Reference: 20.456r05v02

3 August 2021

**Re: TRAFFIX Response to Review of Response to Submissions
TAFE NSW Institute of Applied Technology for Construction
2-44 O'Connell Street, Kingswood (SSD 8571481)**

SITE PLAN - PROPOSED

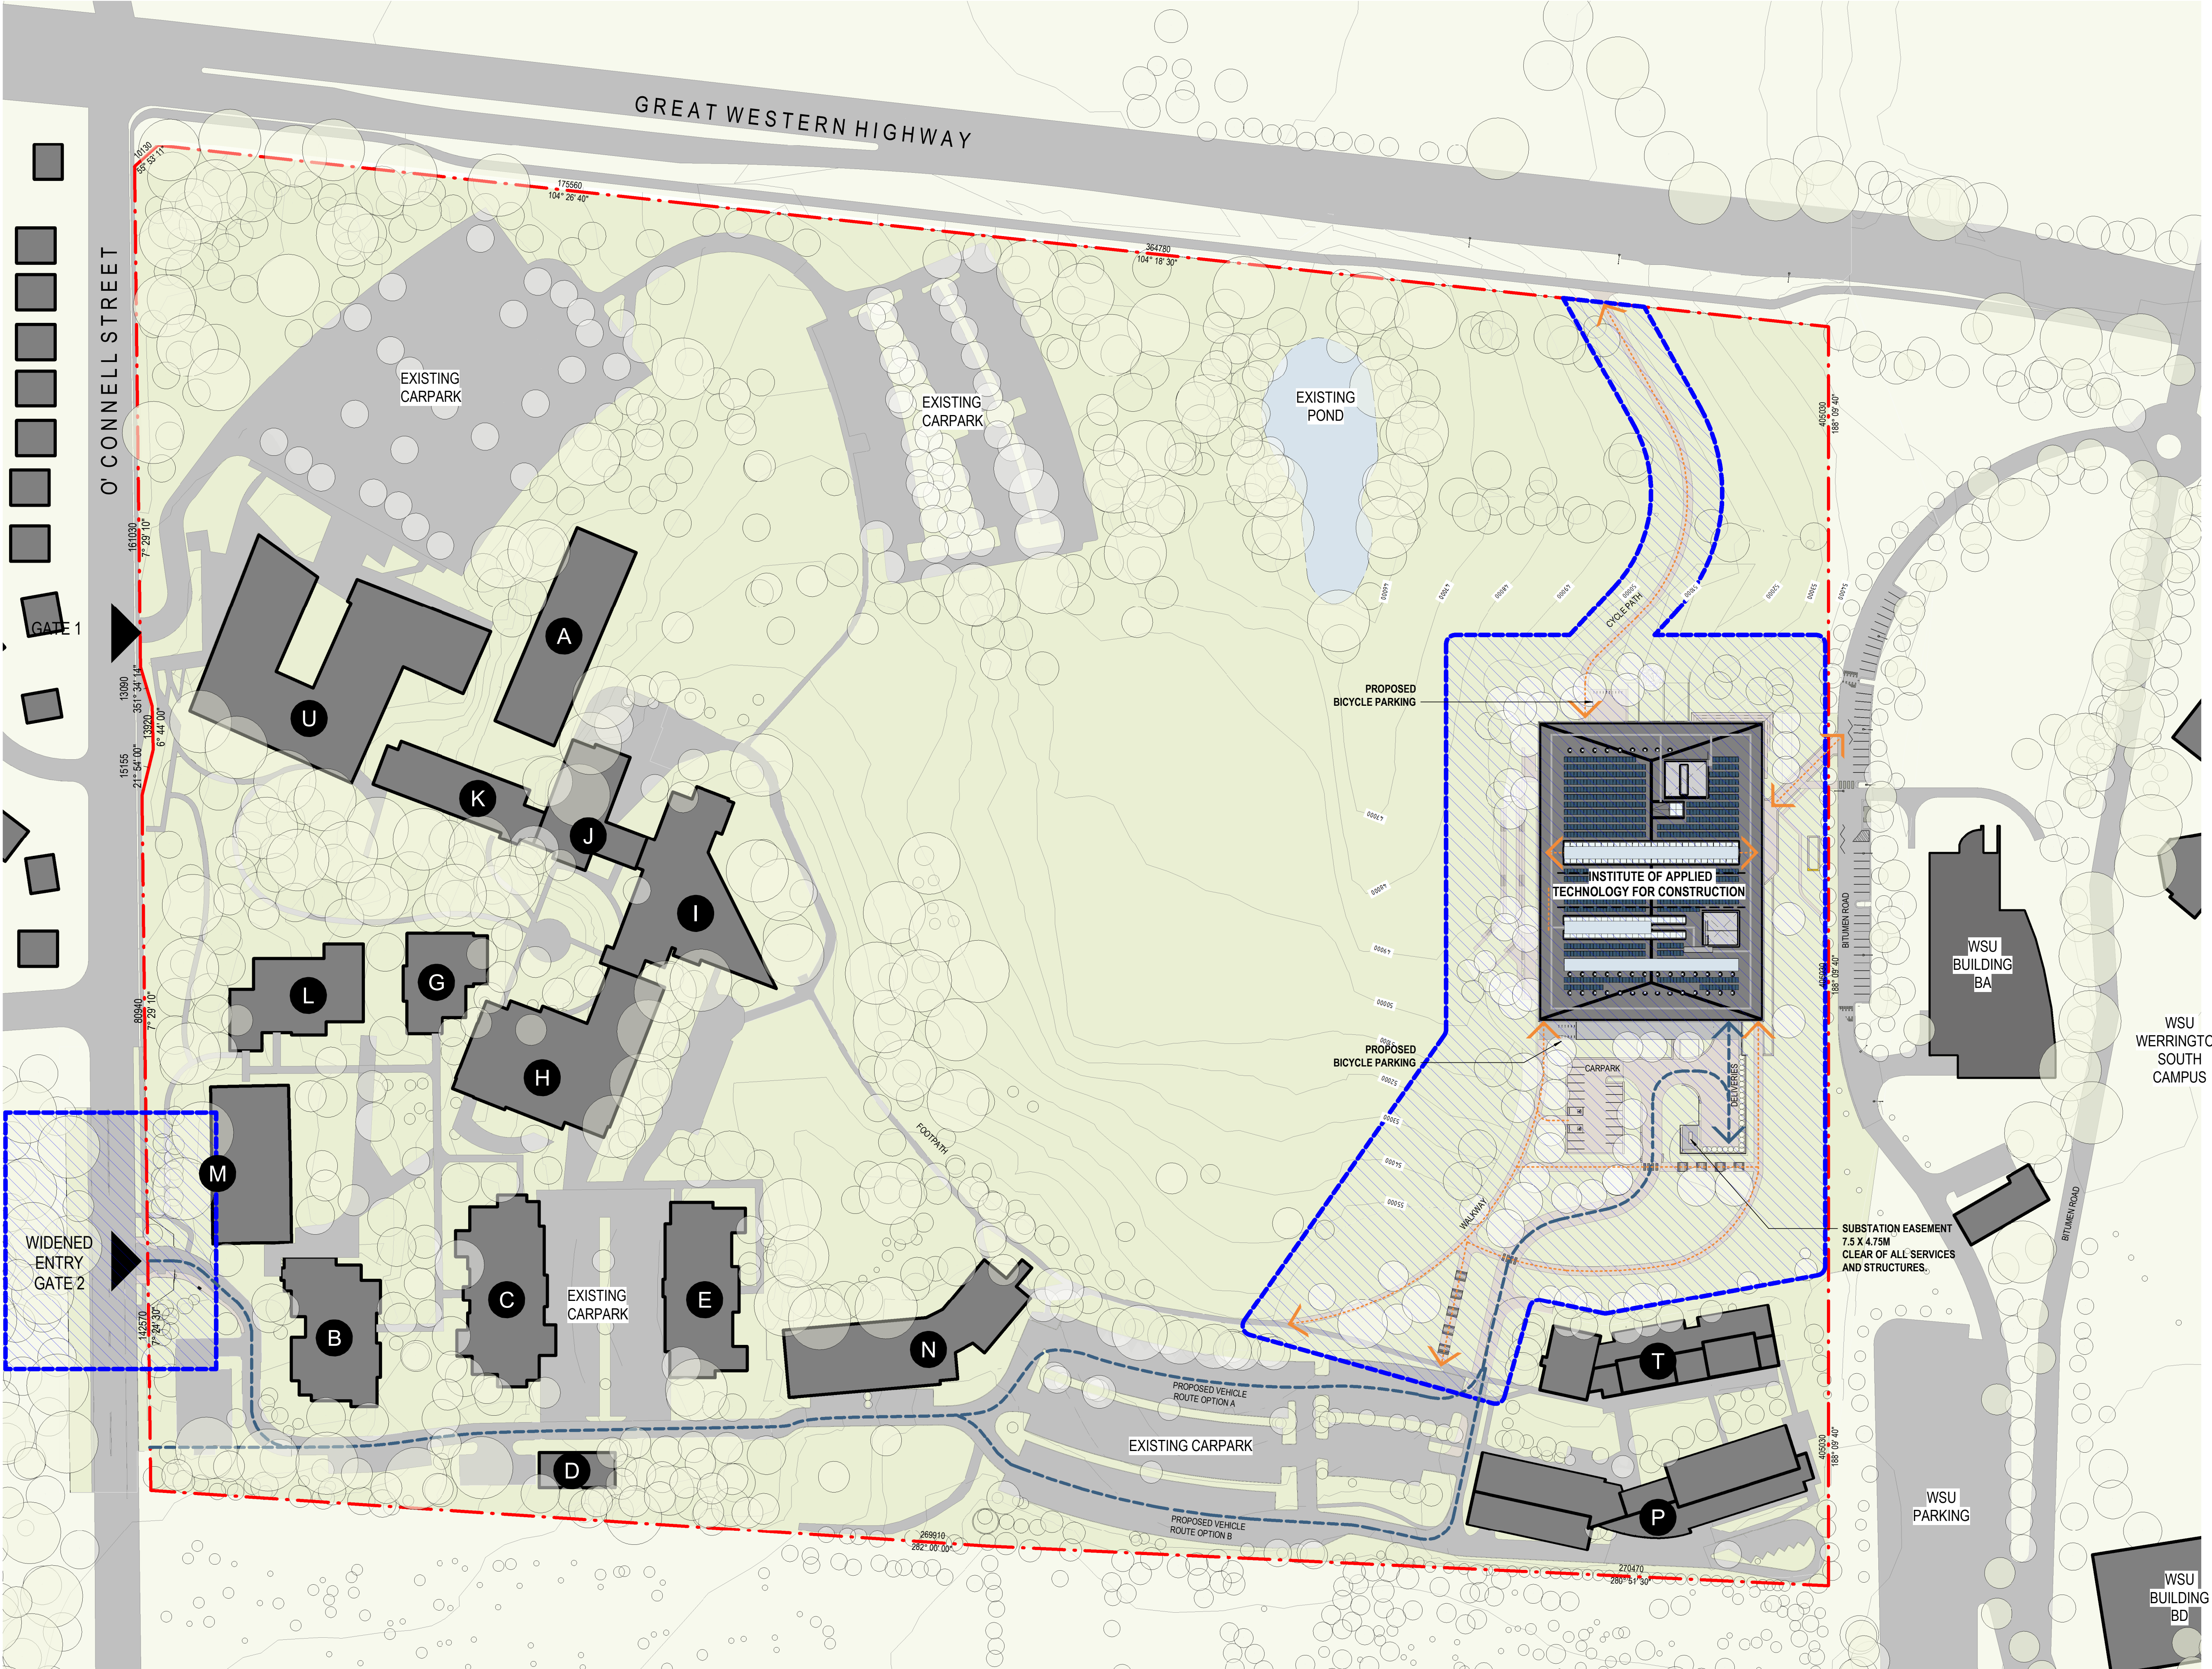
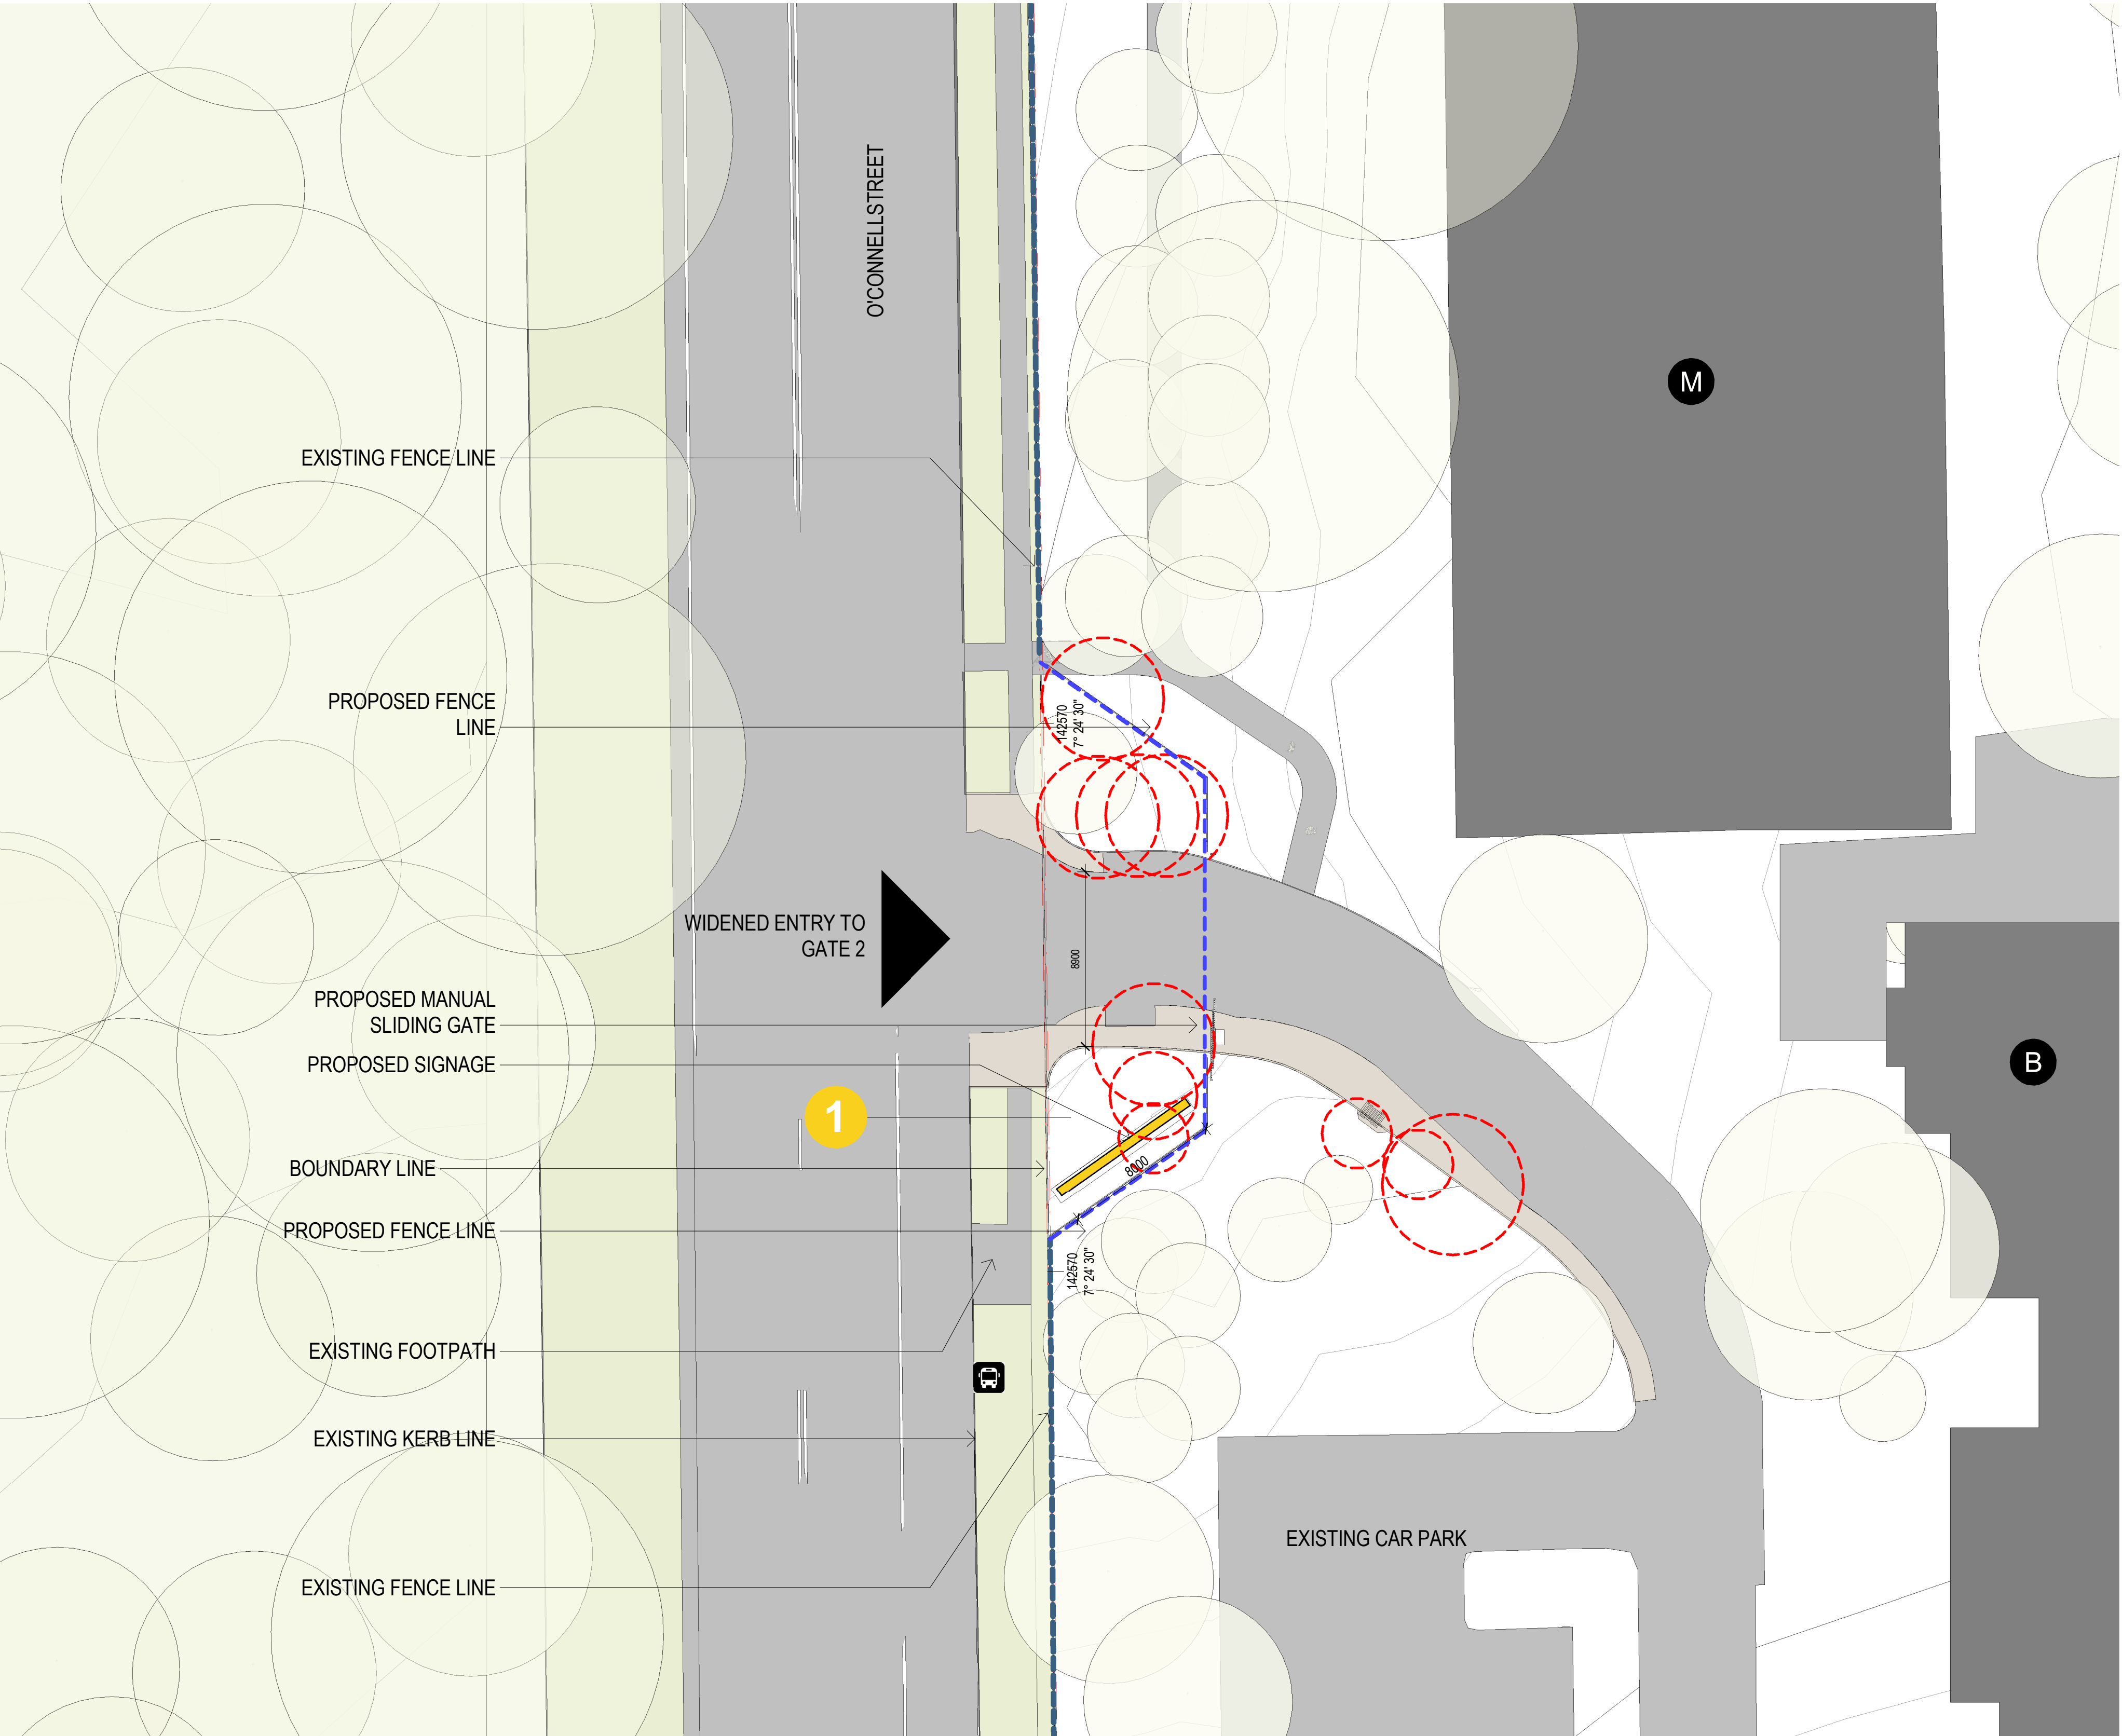
The swept path movements for a 12.5 metre vehicle at O'Connell Street indicate that simultaneous entry/exit cannot be achieved. This can lead to conflict points at the access where 2 opposing vehicles are attempting to use the access at the same time. It is noted that minor works to remove the median (in driveway) and widening of the internal road are proposed. This could extend to the widening at the entrance of the driveway to allow for simultaneous entry exit.

The design of the access point should be widened to allow for simultaneous entry/exit movements of the largest vehicle with a passenger vehicle. However as O'Connell Street is a Local Road, Council is to determine if the development risks raised by TfNSW is satisfactorily addressed by the applicant. Should the driveway be widened the swept path of the longest vehicle entering and exiting the subject site, shall be in accordance with AUSTRROADS and to the satisfaction of Council.

TRAFFIX Response: Reference should be made to the swept path analysis provided in **Attachment 2** showing the amended southern access driveway layout via O'Connell Street which accommodates the largest size vehicle being a 12.5 metre heavy rigid vehicle (HRV) passing a B99 design vehicle at the site boundary. The amended access driveway has been designed in accordance with AS2890.1 (2004) and AS2890.2 (2018). It is noteworthy that the access driveway is not subject to Austroads Guidelines as it is a private driveway and is required to be assess with the requirements of AS 2890.1 and AS 2890.2 in this regard. Notwithstanding, it is emphasised that any requirement for a 12.5m HRV to pass a B99 design vehicle at the driveway crossover will be minimal since HRV's are expected to access the subject development approximately once every two (2) weeks and will arrive and depart outside of TAFE student peak times. The amended vehicle crossover will comfortably accommodate all vehicles accessing the subject site under all scenarios.
